**Consultation Response from KC,  
Trees**

**2023/93667 Storthes Hall Student Village, Storthes Hall Lane, Kirkburton, Huddersfield, HD8  
0WA**

**Date Responded: 26/06/2025**

DRAWING LEGEND:

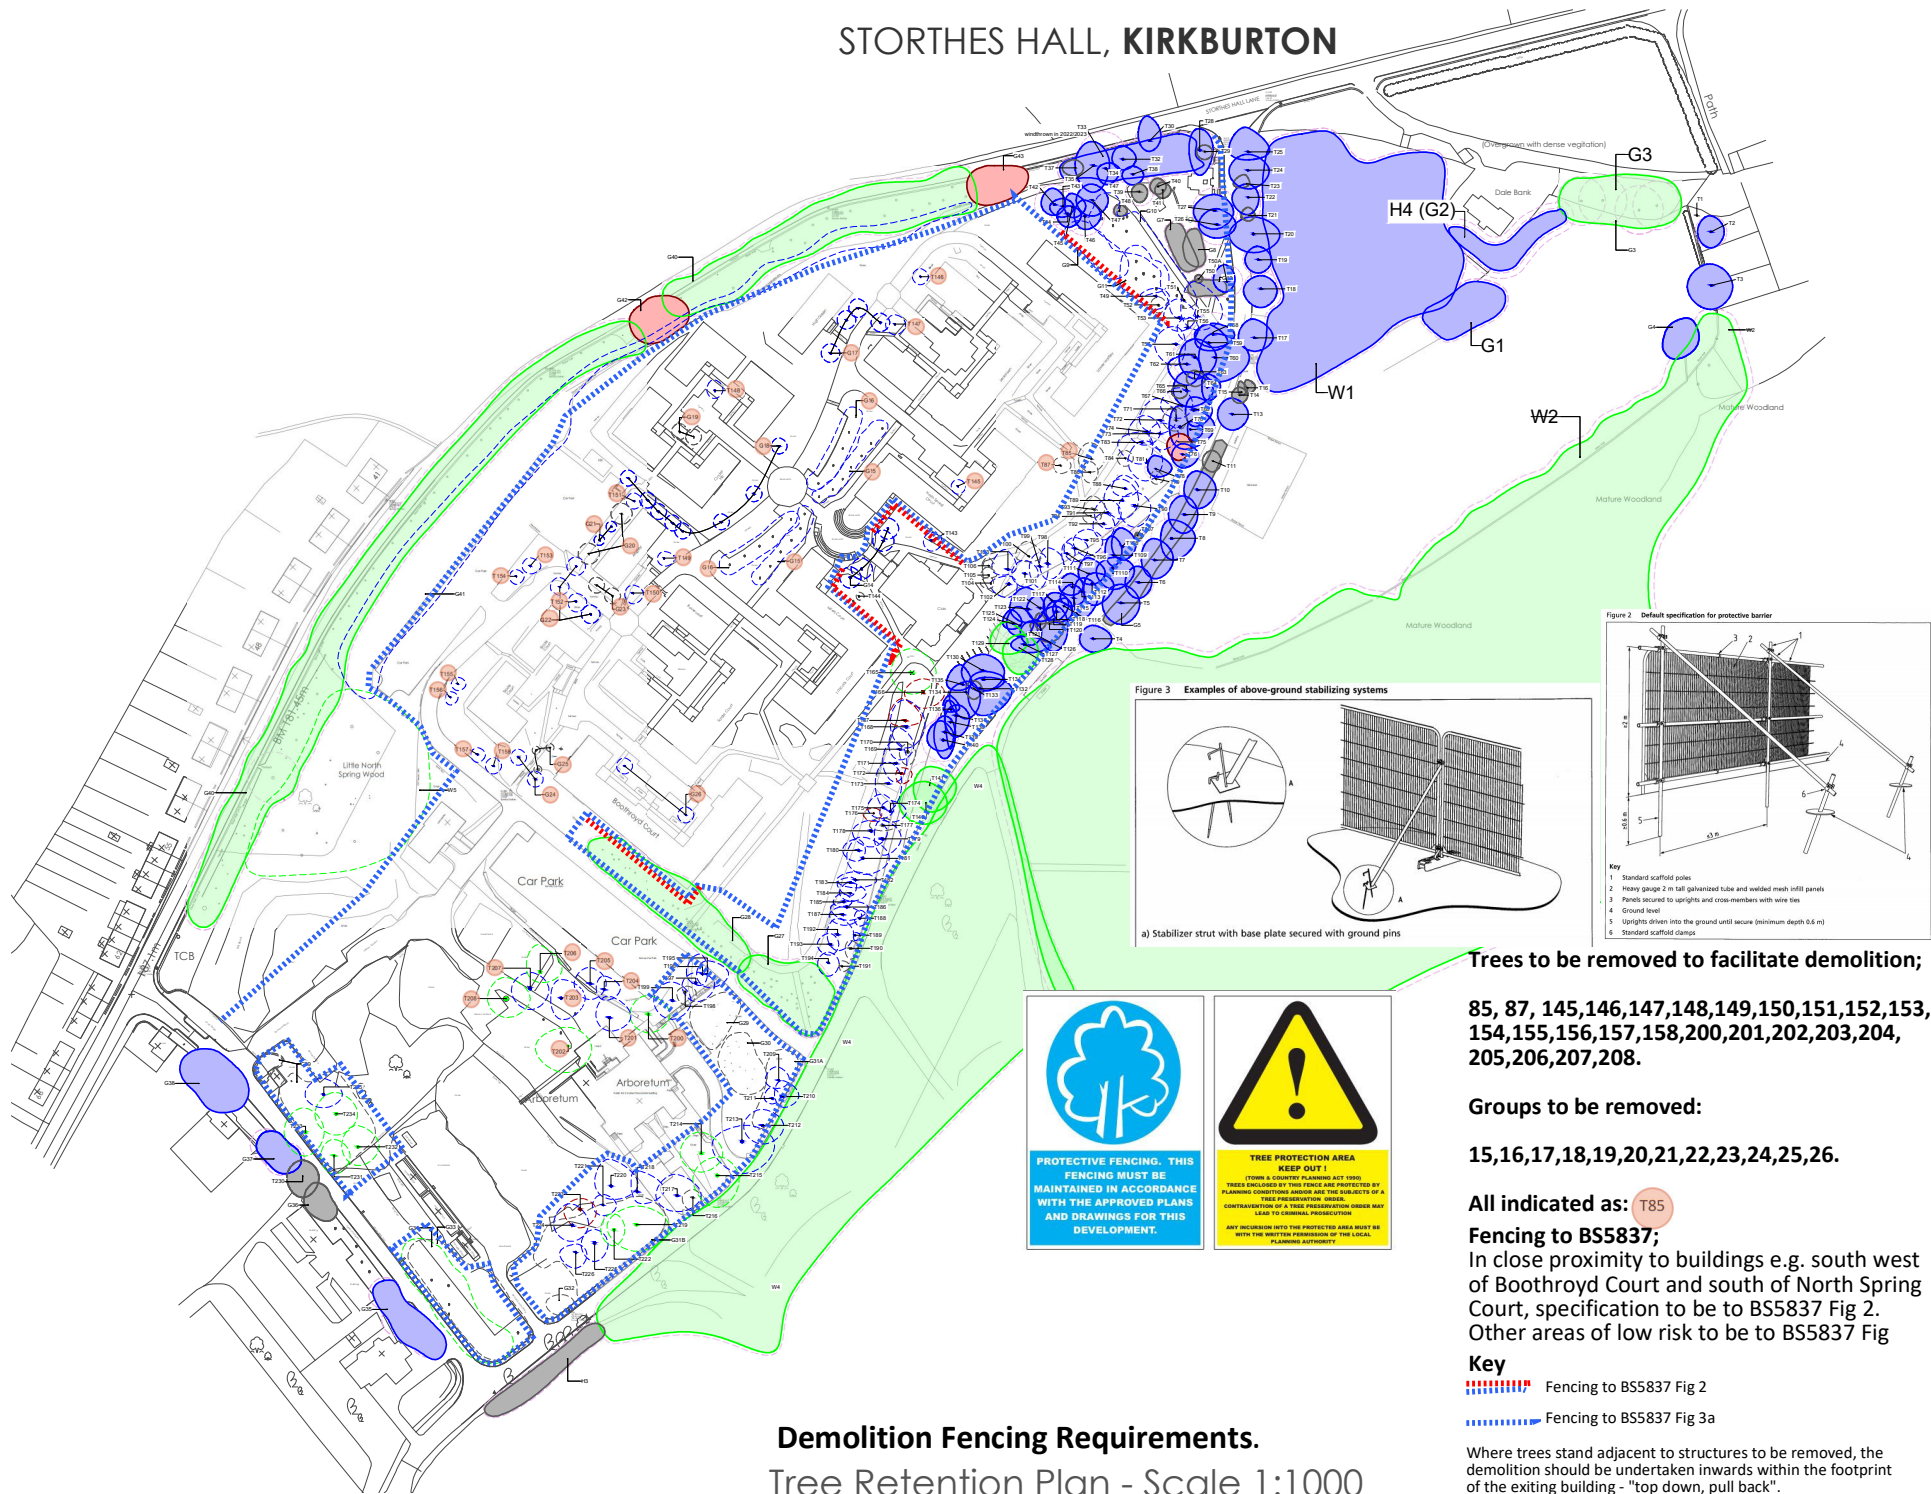
The submitted Demolition Arb Method Statement. Is showing many contradictions. Whilst KC trees is fine with the removal of all the internal trees in the main section of the site surrounding the student blocks it is deemed unnecessary to remove the higher value trees to the rear of the venue/arboretum. It would be possible to demolish this building without the removal of these trees and there for they should be retained and protected during this phase construction. The need for their removal will be judged at a full application phase of development.

The submitted Demolition Arb Method Statement Is showing all the trees to be removed as part of the demolition as having a red circle around the T number but also appears to be showing Category A and B trees for removal in the Drawing legend that have previously be agreed for retention. Furthermore, there appears to be tree protection fencing around these trees which are showing as trees to be removed in the drawing legend, which makes for a confusing document.

There is a holding objection until this document is removed and a new Demolition Arb Method Statement is submitted that is in line with the agreed parameters plan.
